City of Albuquerque

June 5, 2001

**Re: Grading and Drainage Plan for Metro Court Parking Structure,
(J-14/D105A), Engineer stamp dated 5/30/2001.**

The above referenced report is not approved as submitted, and the following comments will need to be addressed.

GRADING PLAN

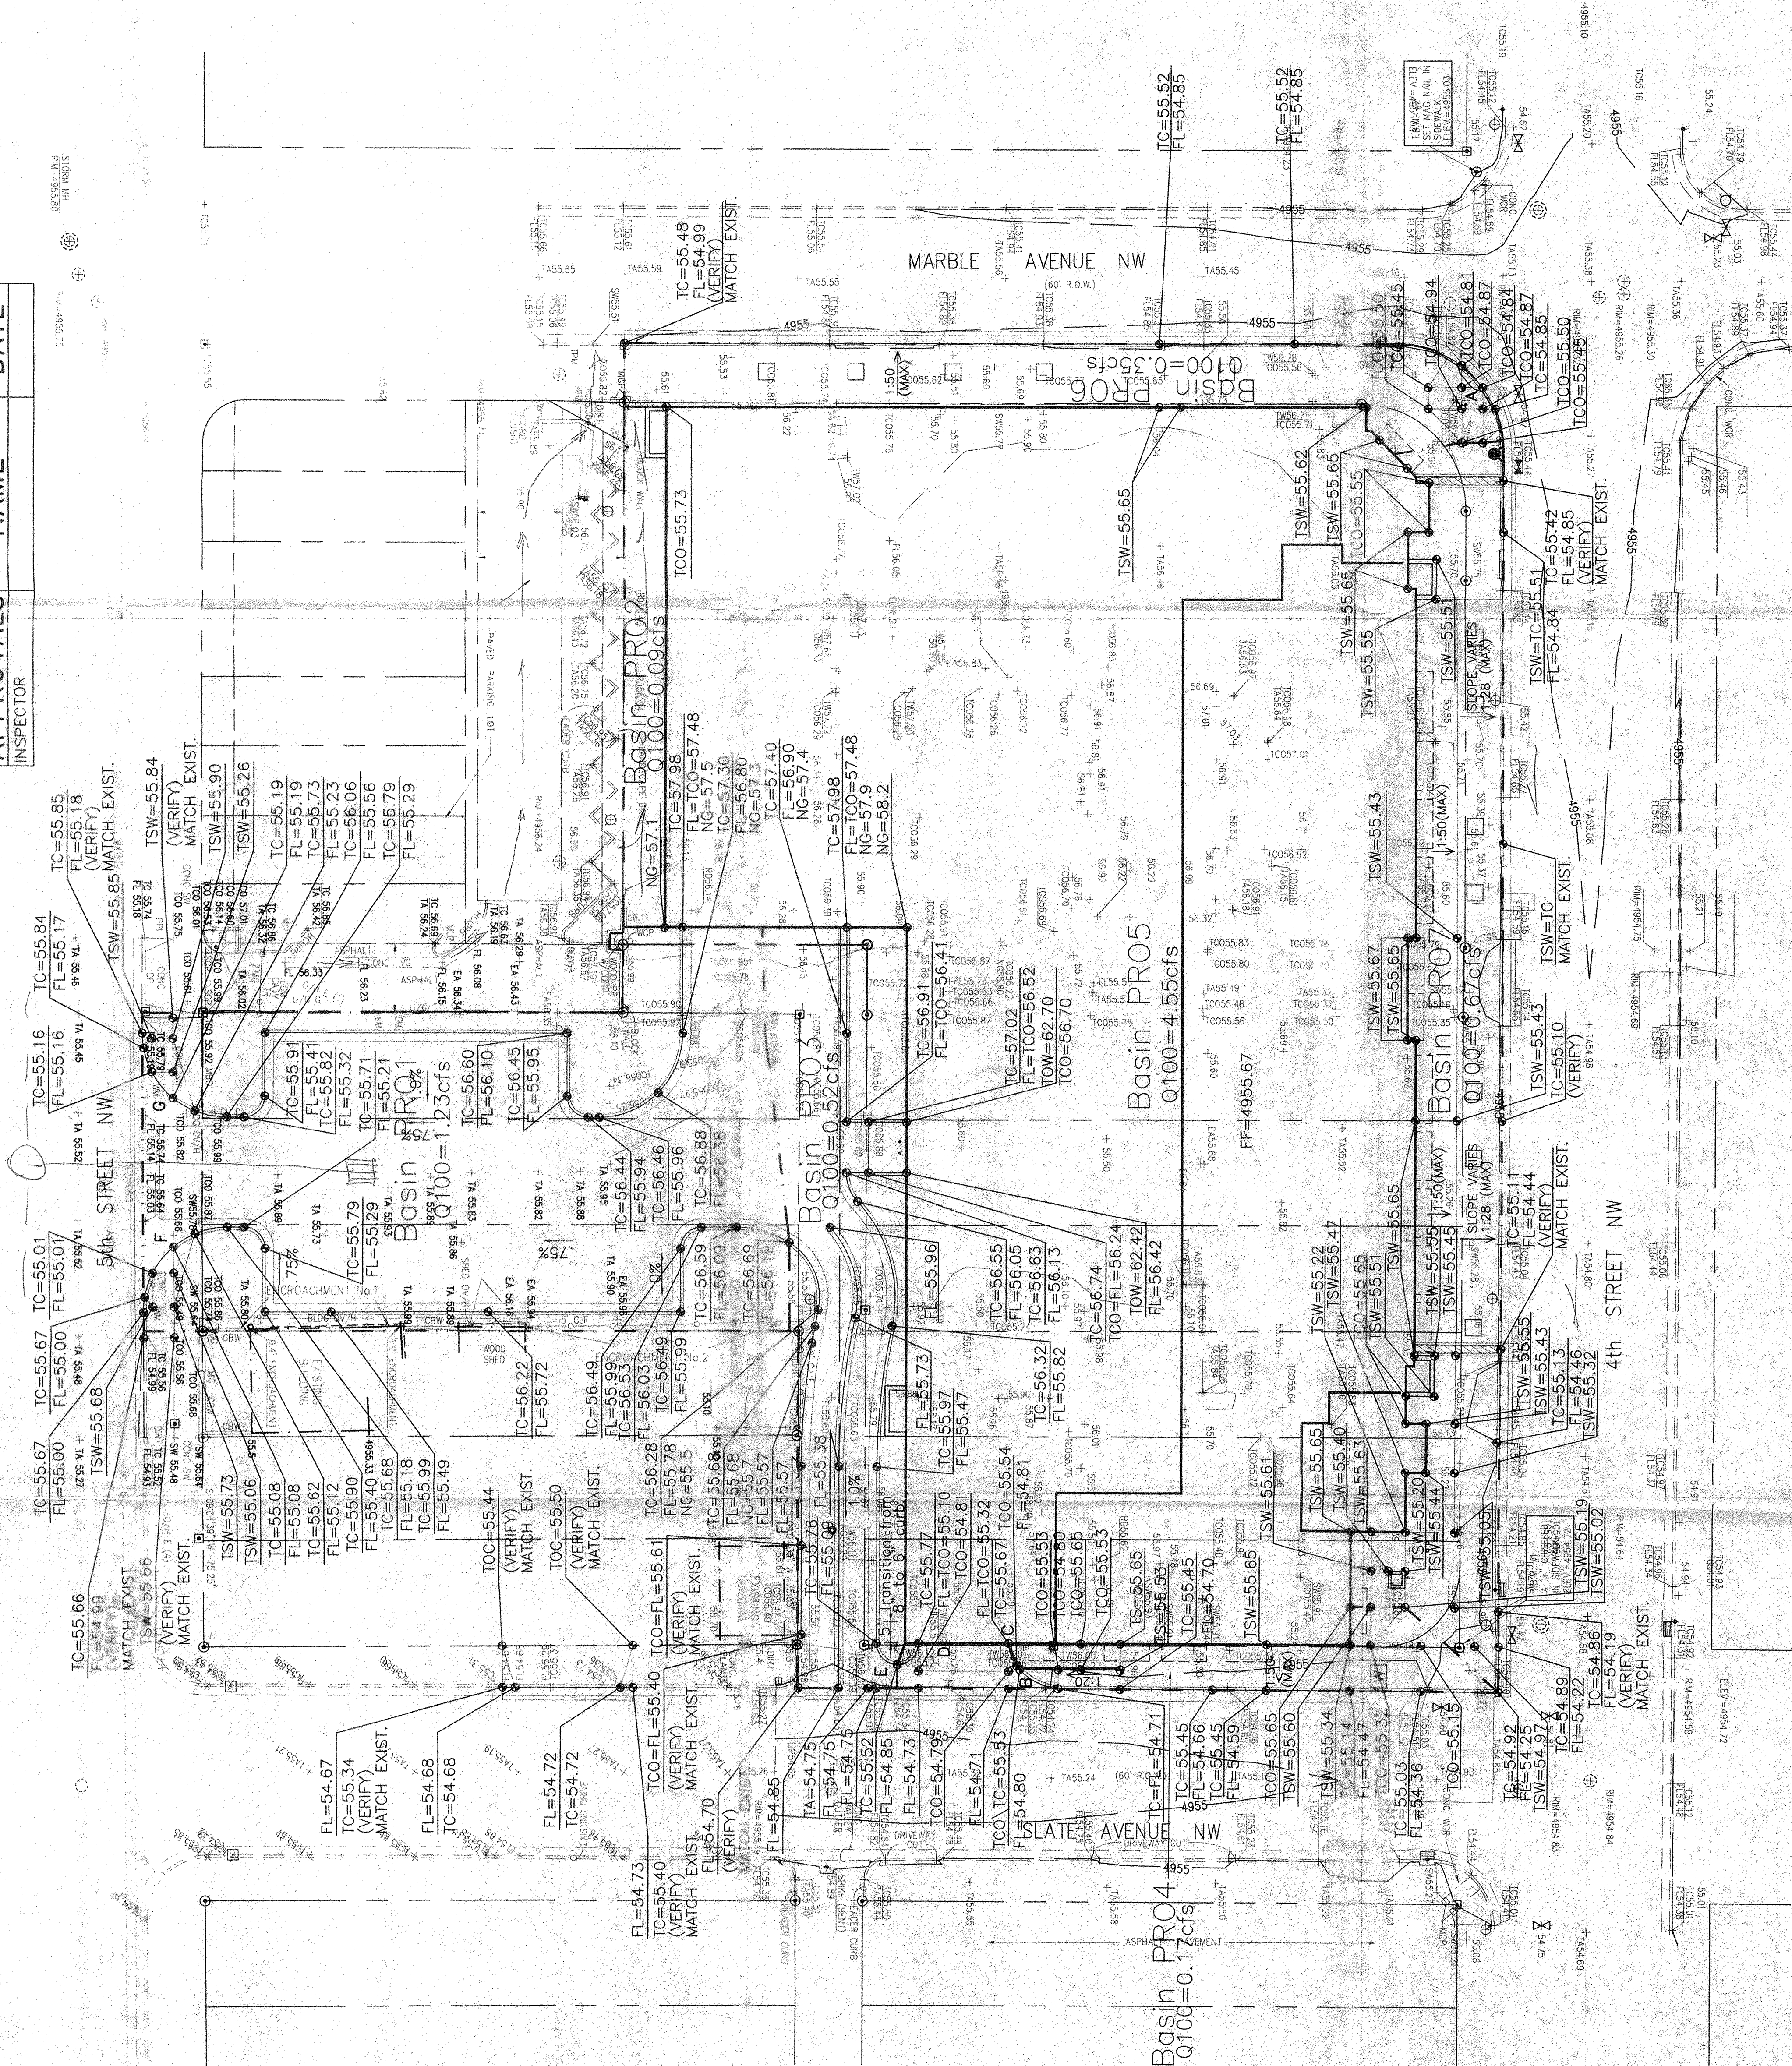
1. The driveway approach on 5th Street needs to be designed with a curb-height water block at the right-of-way line. I suggest that you investigate installing an inlet in the parking lot and making direct connection to the storm drain in 5th Street.
2. The landscape area adjacent to the east side of the residential units parking area should be designed with a drainage swale draining to Marble Ave. to prevent runoff from draining to the west.
3. Show the roof drains for the building draining to 4th Street, as planned.
